# **Summary of Oral Submissions at Issue Specific Hearings**

**Application by ESSO Petroleum Company Ltd  
for an Order Granting Development Consent  
for the Southampton to London Pipeline  
Project**

**Application Reference EN070005**

## RUSHMOOR BOROUGH COUNCIL

Figure 1 – Current proposals for pipeline installation through QEP section of the SLP pipeline route

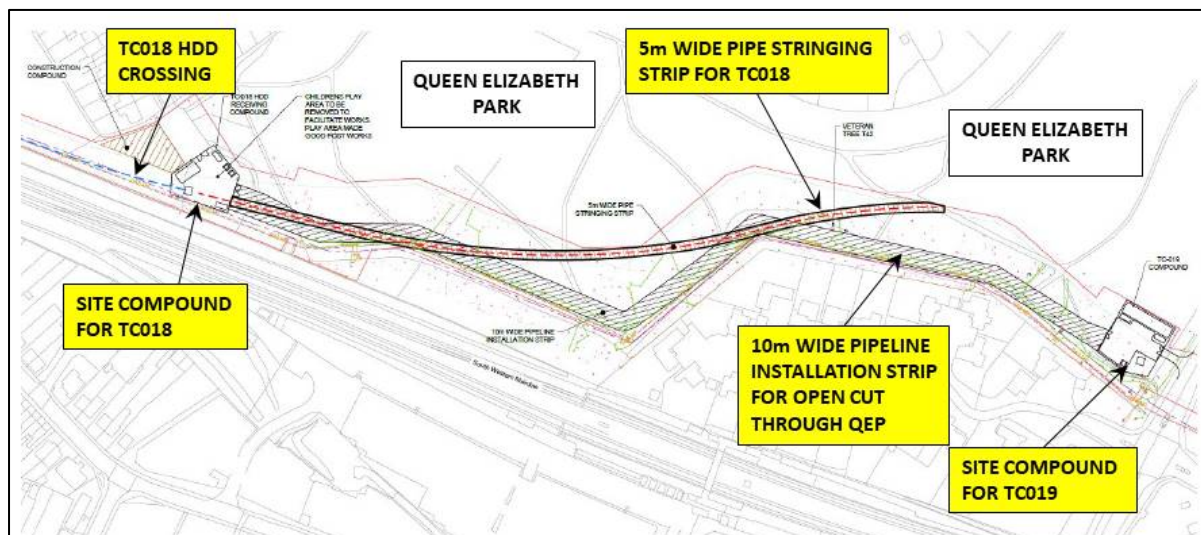
- t. In the SSP the work to the trees uses the NJUG guidance. This needs to be updated to the British Standard (BS) since the Applicant has now committed to comply fully with the BS. If the BS standards were used it will not be possible to trench in QEP as the BS requires HDD within all veteran tree Root Protection Zones for utilities projects. Therefore, trenchless methods will need to be used in QEP.

- v. RBC would like to clarify that the local authority is promoting trenchless working in QEP. This might result in a temporary impact in Farnborough Hill School grounds and the conservation area, which is accepted.
